Rezoning Transportation Analysis
Petition Number: Insert Zoning Petition #2021-239
General Location Identifier: 10501221

Revision Log:	Date	Description
	02-18-2022	First Review (AO)

The site is located on E WT Harris Blvd, a State-maintained major thoroughfare, District Drive, a State-maintained local street, and Shorthorn Street, a City-maintained local street. A Traffic Impact Study (TIS) is not needed for this site. Site plan revisions are needed to meet ordinance requirements and/or the outstanding items including, but not limited to dedicating right-of-way from the road centerline of District Drive, constructing an 8-foot planting strip, and 6-foot sidewalk on District Drive, constructing a 12' multi-use path along E WT Harris Blvd outside of the control of access and within a public access easement, and shifting an access point along Shorthorn Street to Damascus Street. Further details are listed below:

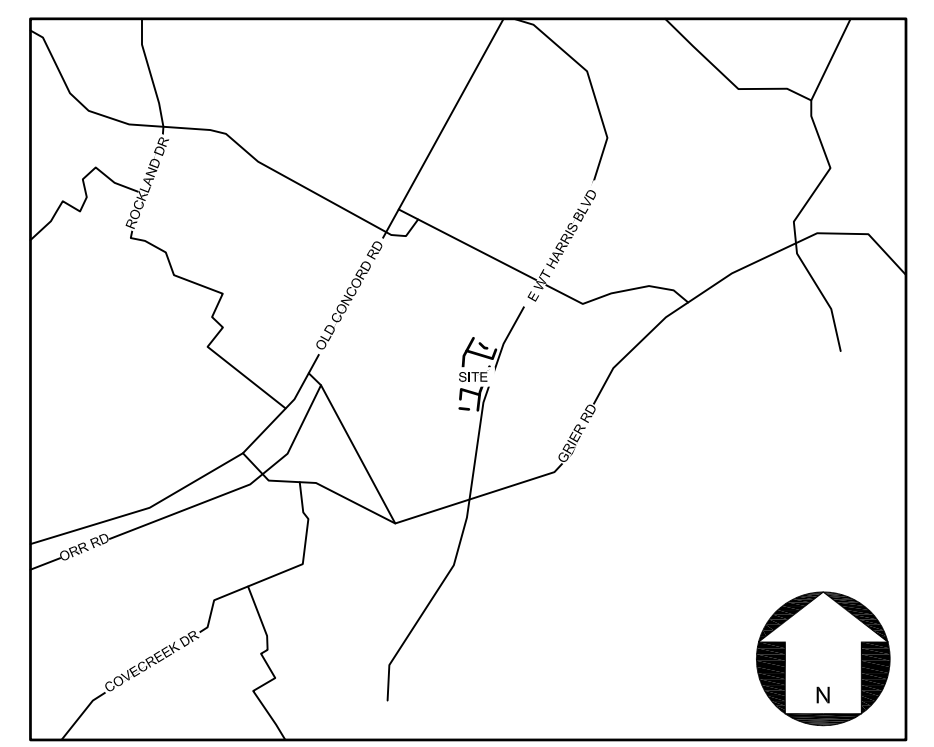
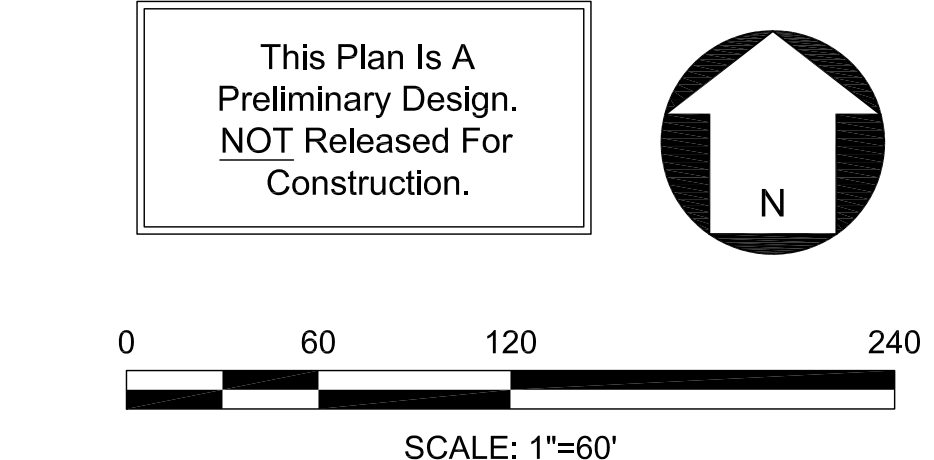
2. Revise site plan and conditional note(s) to commit to dedicating right-of-way from the road centerline of District Dr. The site plan shall label and dimension the right-of-way from the road centerline.

3. Revise site plan and conditional note(s) to commit to construct an 8-foot planting strip, and 6-foot sidewalk on District Dr per Chapter 19 / Chapter 20. The site plan shall label and dimension both items from the back of curb and gutter and road centerline.

4. Site plan and conditional note(s) revisions are needed to commit to construct bicycle facilities by installing a 12' multi-use path along E WT Harris Blvd outside of the control of access and within a public access easement to meet the City Charlotte BIKE Policy.

5. Revise site plan and conditional note(s) to shift access point to existing Damascus St and removing one other access point along Shorthorn St.
6. A site plan note(s) specifying dedication and fee simple conveyance of all rights-of-way to the City before the site's first building certificate of occupancy is issued as needed. CDOT requests rights-of-way set at 2' behind back of sidewalk where feasible.
